From:
Sent: 20 August 2026 13:48
To: DC Admin
Cc: Cllr Anthony Smith
Subject: No 4 Final Comment: Revised plans - Planning application 2026/91900

I am writing with one final representation following the revised plans and after reviewing the previously approved application 2020/90621.

Subject: Revised plans - Planning application 2026/91900 – Supplementary objection regarding access to No. 68

Proposed Ground Floor Plan

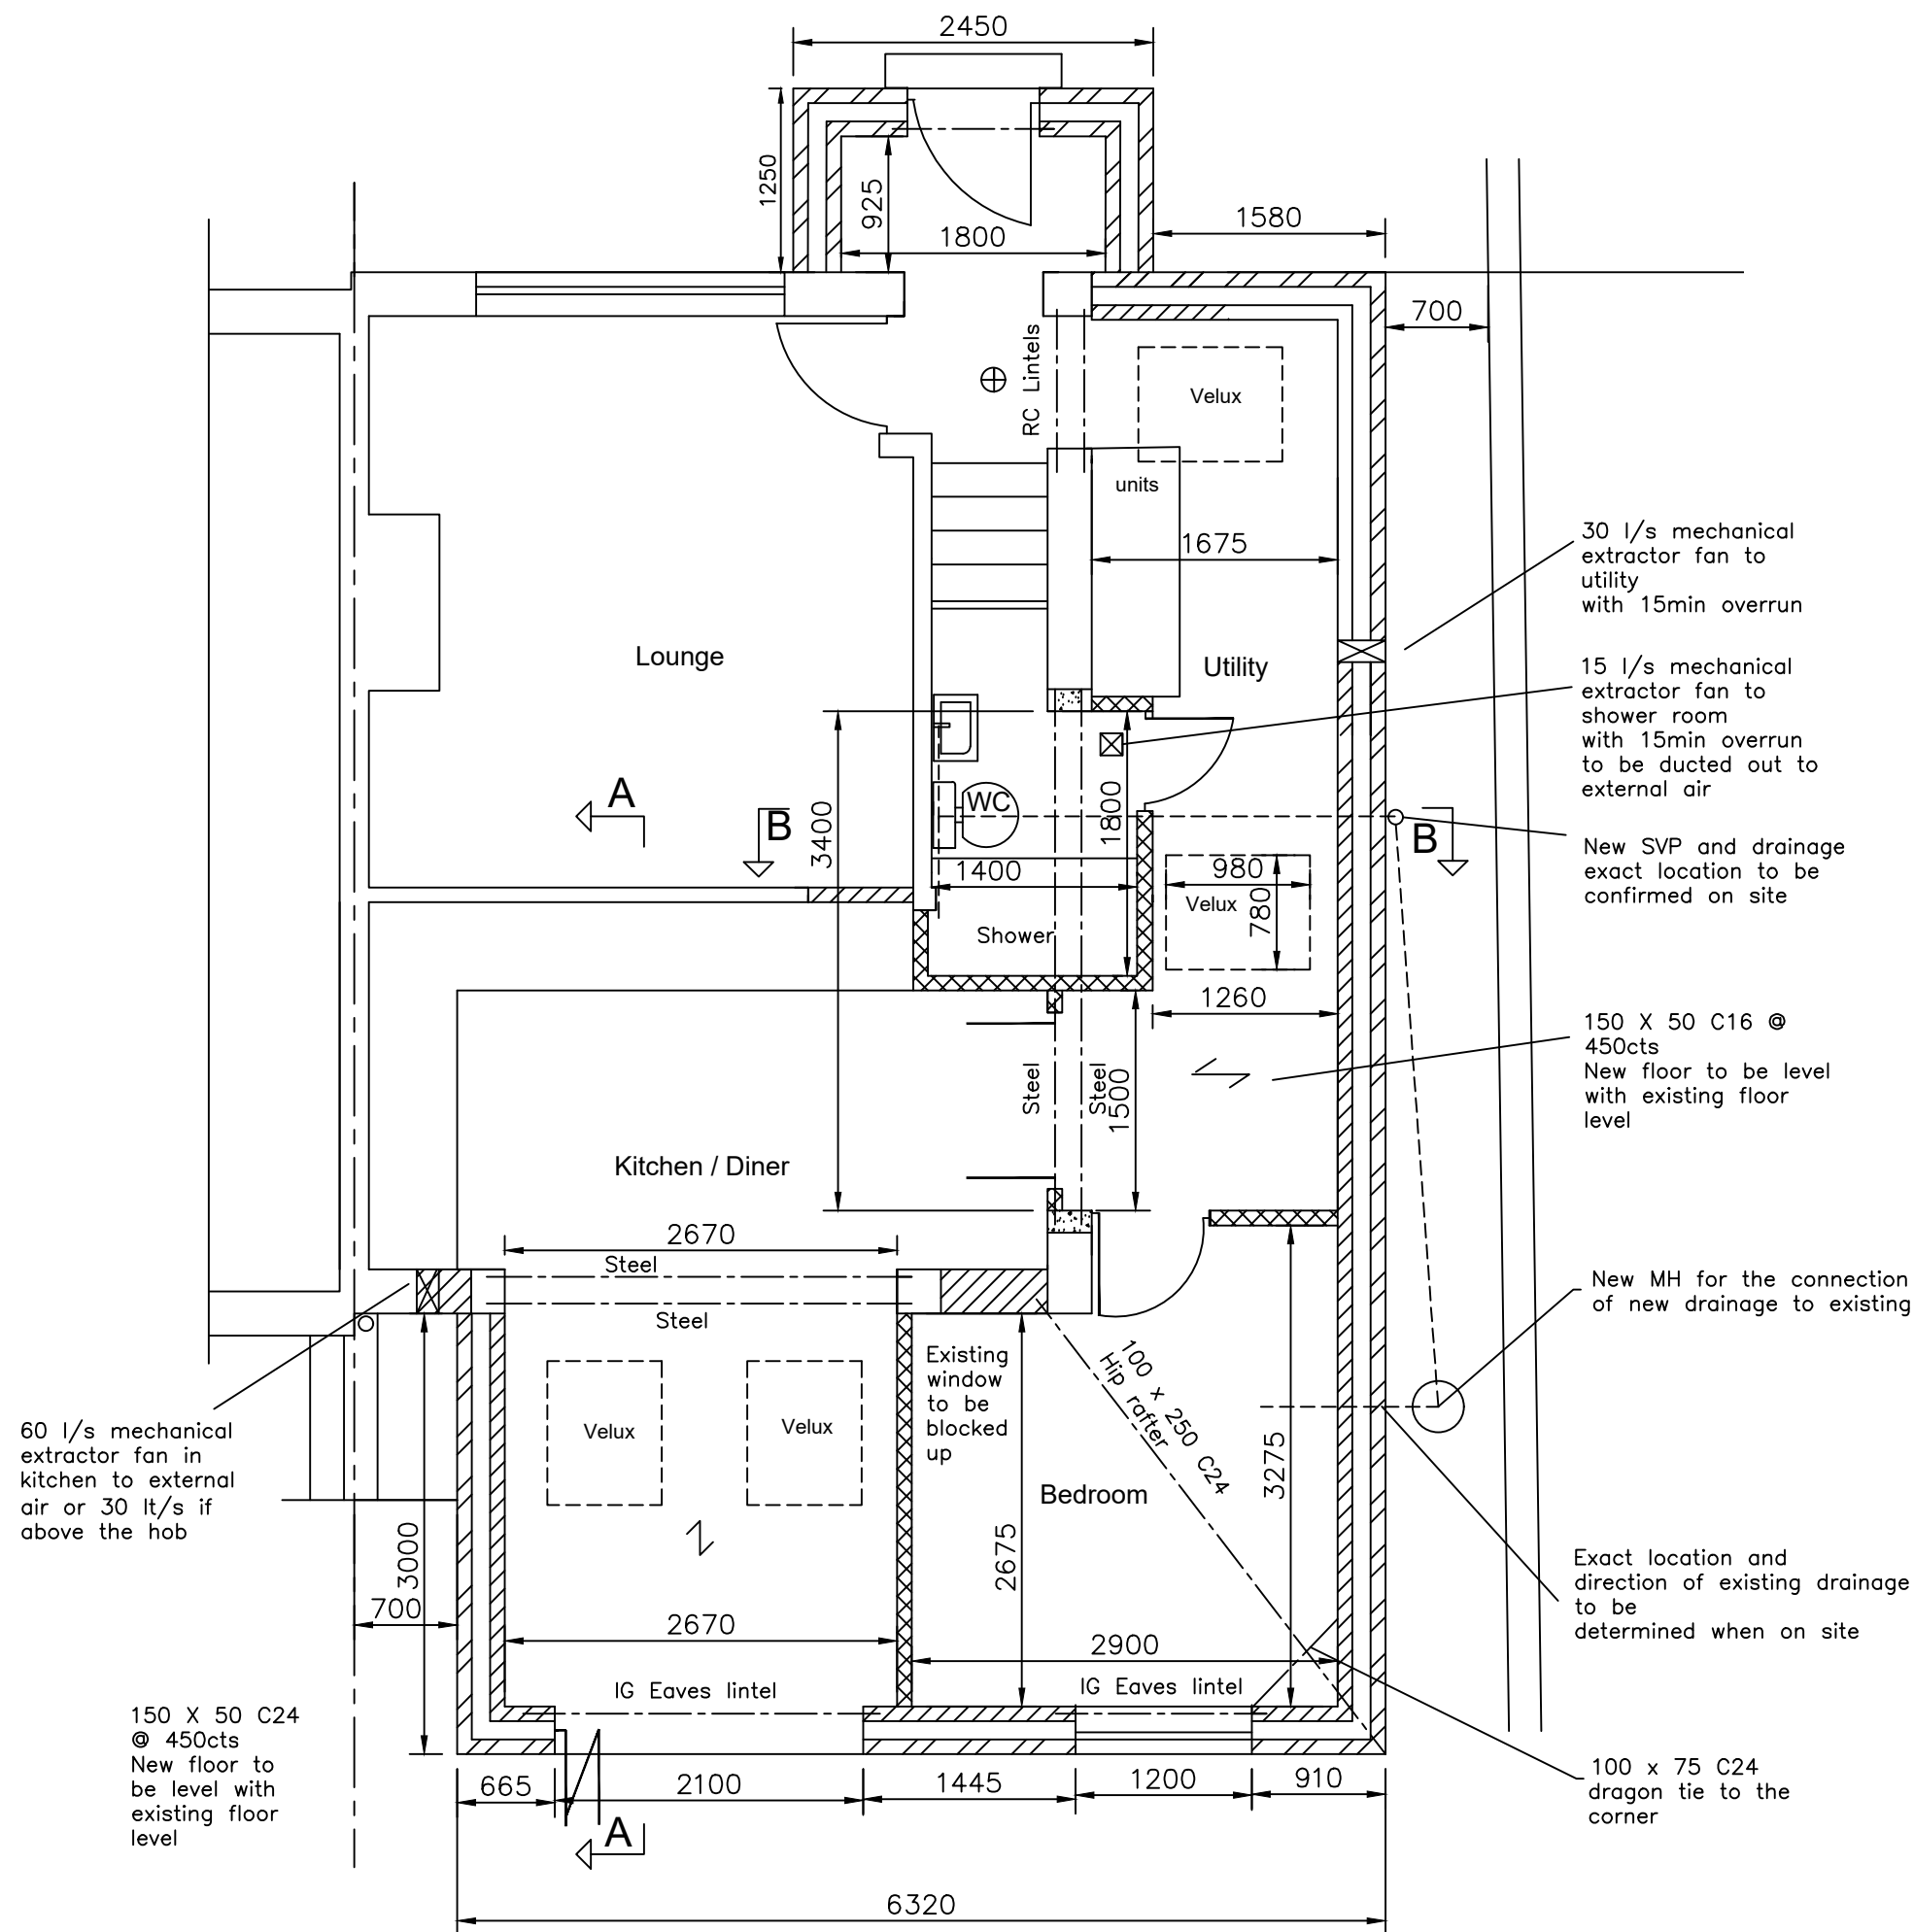
This appears particularly relevant because the approved 2020 ground-floor plan showed the rear extension at approximately 5.665m wide and showed approximately 955mm at the access beside the rear extension.

The revised 2026 proposal now shows a rear extension approximately 6.15m wide and an 800mm dimension.

Although I appreciate that each application must be considered on its own merits, the current extension therefore remains approximately 485mm wider than the previously approved rear extension, with less separation at the side.

The revised 2026 ground-floor plan itself shows different dimensions along this side, including 770mm and 800mm, rather than demonstrating a continuous 800mm clear route.

I would therefore respectfully ask that the physical position of the steps, gate, recess and boundary is checked against the revised drawing before relying upon the stated 800mm measurement.

I am therefore concerned by the revised plan showing a new manhole and drainage connection while stating that the exact location and direction of the existing drainage are still to be determined on site.

The revised plan appears to measure the 800mm from the straight boundary/fence line to the proposed extension.

However, the existing three steps and gate project into this area, and the existing wall has a recessed section which is not represented in the same way as on the previously approved 2020 plans.

My concern is therefore not simply the numerical width shown on the drawing, but whether the revised proposal actually provides 800mm of clear, usable access once the existing steps and gate arrangement are taken into account.

The revised drawing now refers to a new manhole and new drainage connection, but also states that the exact location and direction of the existing drainage is to be determined on site.

Given the existing surface-water problems affecting my garden, I would ask that the proposed drainage arrangements are properly established before determination and that the development does not increase surface-water runoff or otherwise worsen drainage affecting my property.
